Camden Council

2 September 2016

RE: State Significant Development Application SSD 7387

**PROPERTY: A Gregory Hills Drive, Gledswood Hills
Lot: 845, DP: 1203105**

OUTLINE OF EAST ELEVATION (AS SEEN FROM THE HERMITAGE WAY)

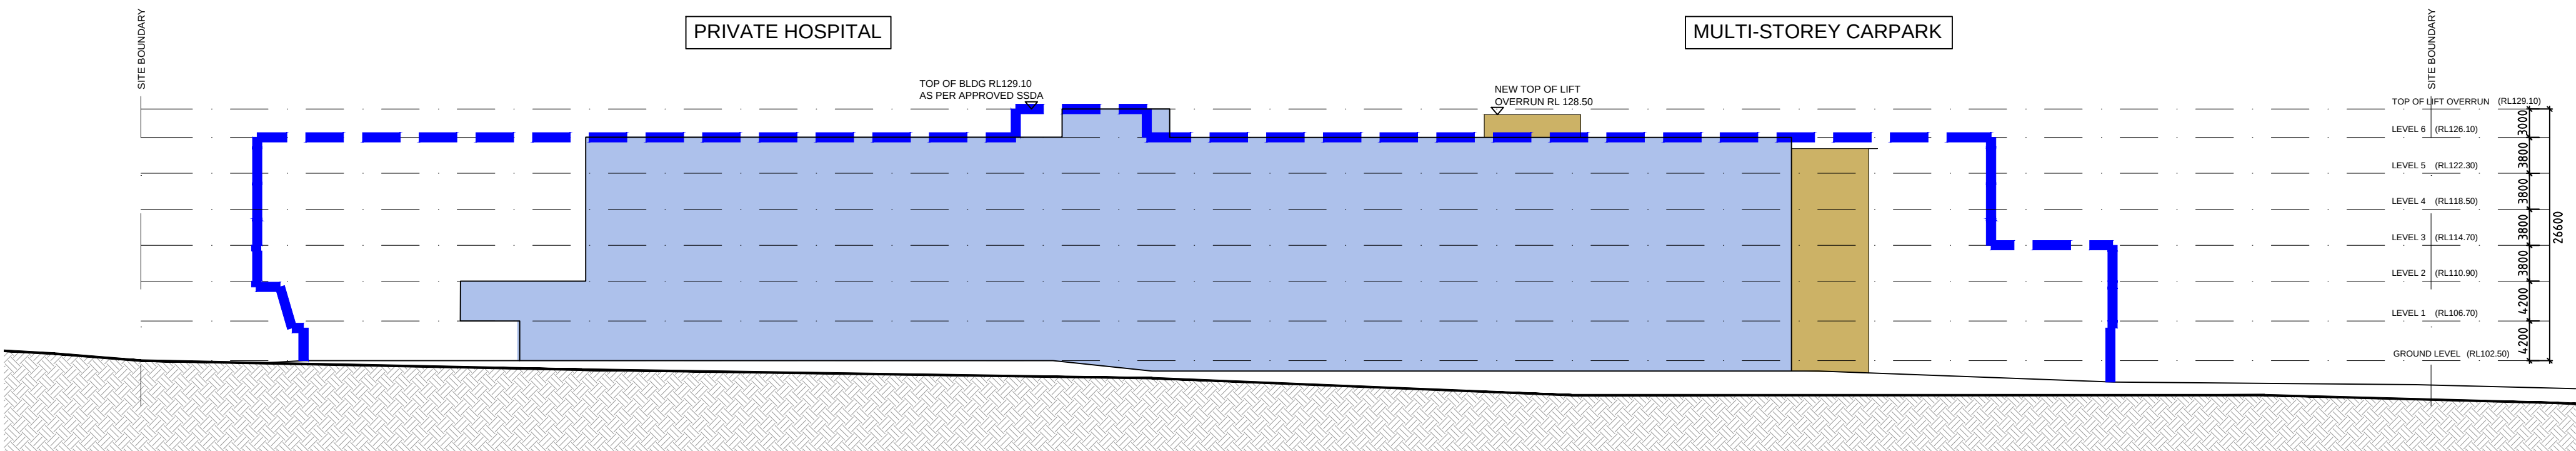
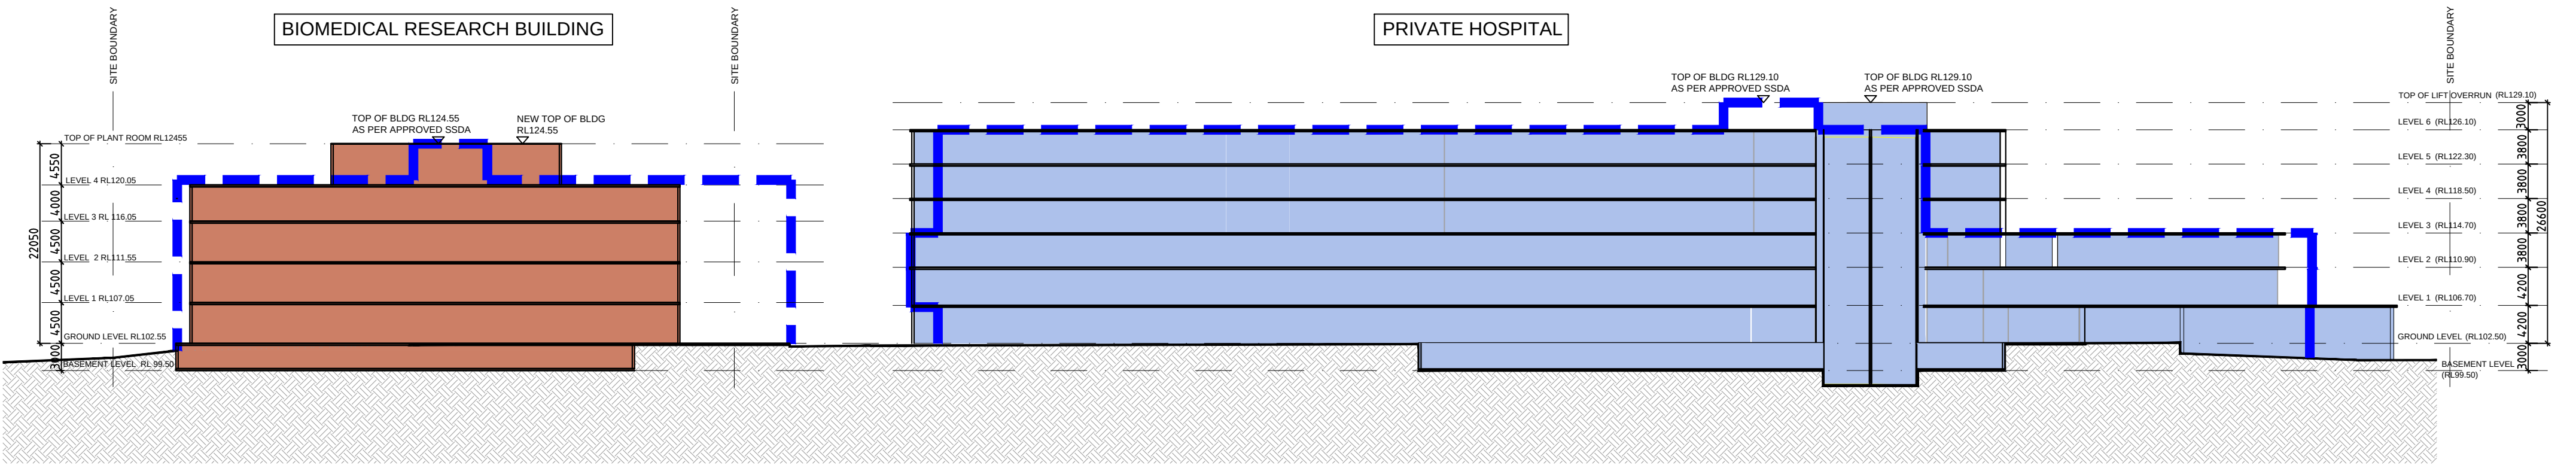
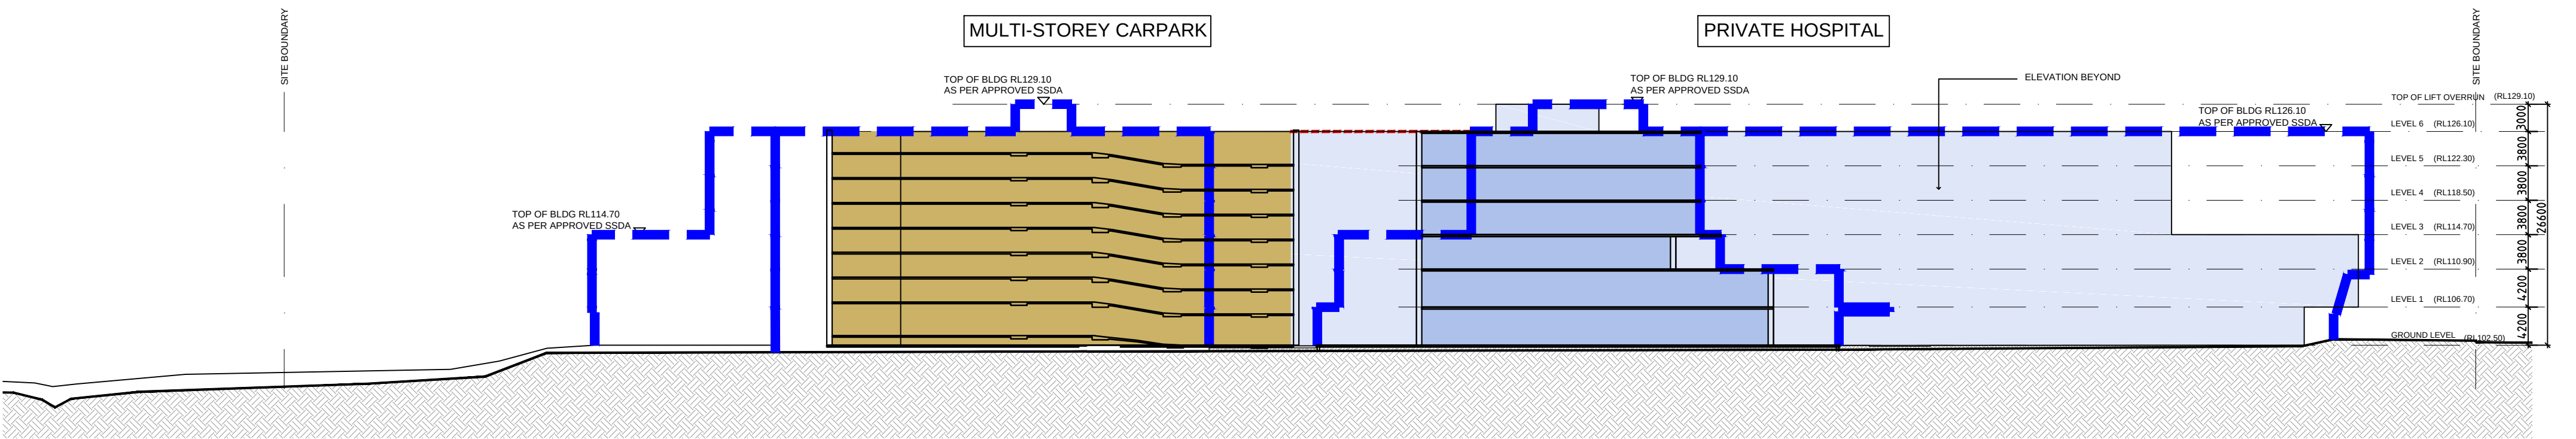
7. A landscaped buffer with a minimum width of 2m must be provided along the site's frontage adjacent to the riparian corridor.
8. Indicative details/perspectives of the proposed development's presentation to the adjacent riparian corridor and land to the south/south west should be provided to understand the visual impacts from those elevations.

Figure 3 Section of proposed hospital envelope showing the maximum height of the development. The second image demonstrates where the section has been cut (Source: HPI)

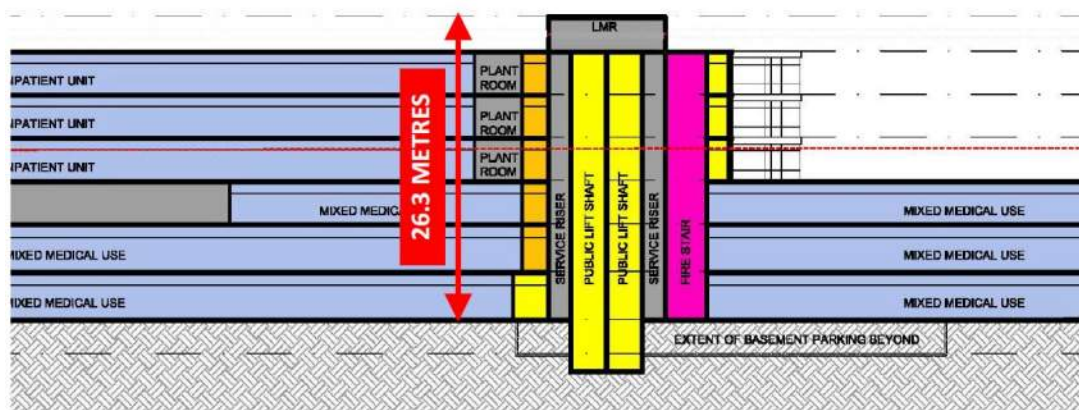
1. The proposed development includes a significant variation to the maximum building height development standard that applies to the site. The merits of this variation and its impacts upon the surrounding area, in particular the impacts upon the residential properties to the east and south east, must be carefully assessed by the Department.
2. The proposed development's interface with adjacent land, in particular the residential properties to the east and south east, is of critical importance. These residential properties generally contain single storey detached dwellings and present a much lower density character than that of the adjacent B5 Business Development zone. The Department must carefully consider the appropriateness of the interface of the proposed
